**Subject:** FW: 3/2022/1158 Land South of Accrington Road Whalley

**Reference** 3/2022/1158

**Location** Land South of Accrington Road Whalley

### Lancashire County Council - Public Rights of Way provides the following comments;-

TITLE: **S104 SUDS DETAILS**

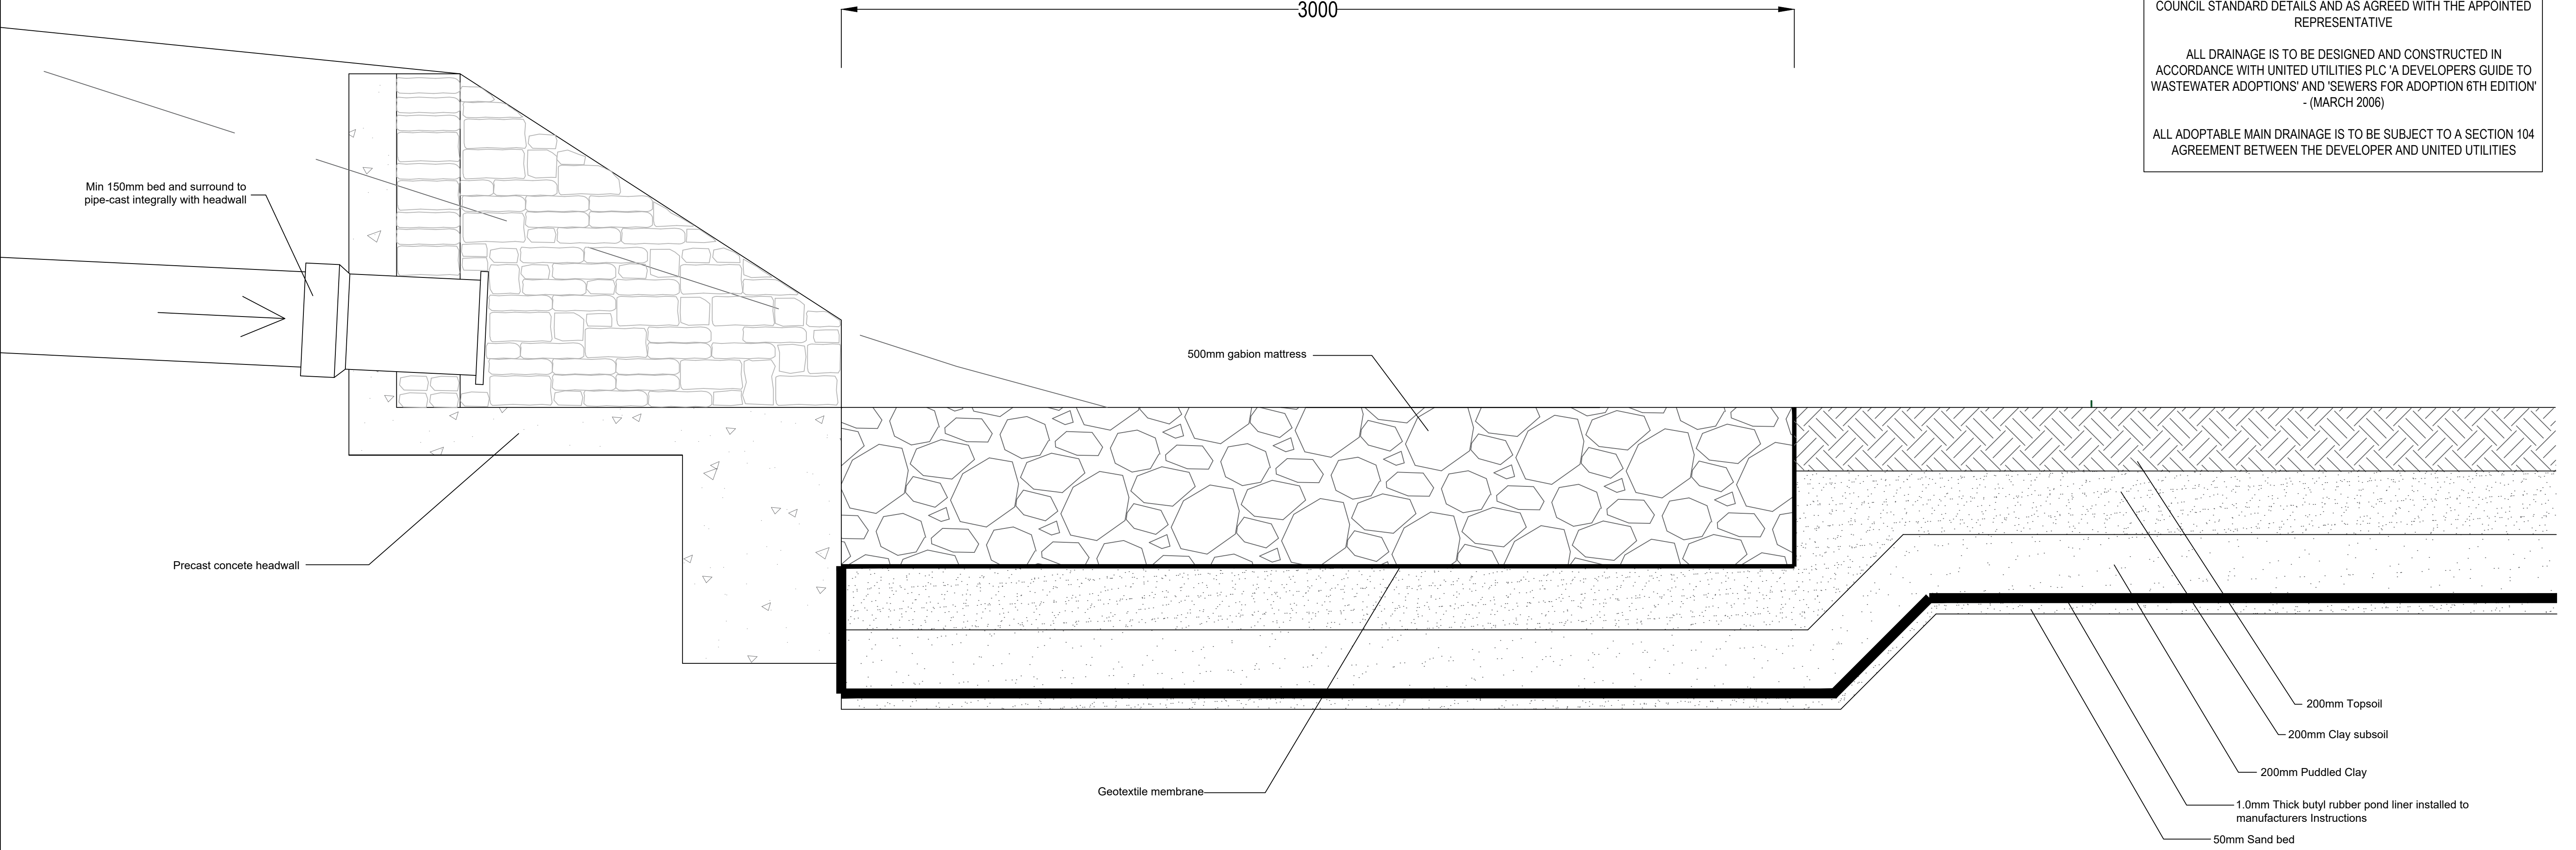
The Reduced Development Proposal Drw No. 015/R-OAK/01 and Phase 1 Drainage Layout removes the previously proposed footpath round the southern boundary of the development repurposing the south east corner of the site for SUDS features, including a series of drainage outlets running under Footpath FP0345027 into the River Calder.

If the original proposed footpath is omitted from the development there must be a minimum width of 3 meters between the northern edge of Footpath FP0345027 and the SUDS features.

Any changes in ground level or installation of drainage should ensure that surface water is not channelled towards or onto a public right of way either within the proposed development site or in close proximity – this is to ensure public rights of way are not exposed to potential flooding or future maintenance issues.

To protect and enhance the public right of way and provide opportunities to promote walking, it is request the footpath be reintroduced into the development linking to FP0345027 on the eastern boundary of the site and in the south west corner behind 21 Westfield View. The paths here mentioned be a minimum width of 2m with a bound surface.
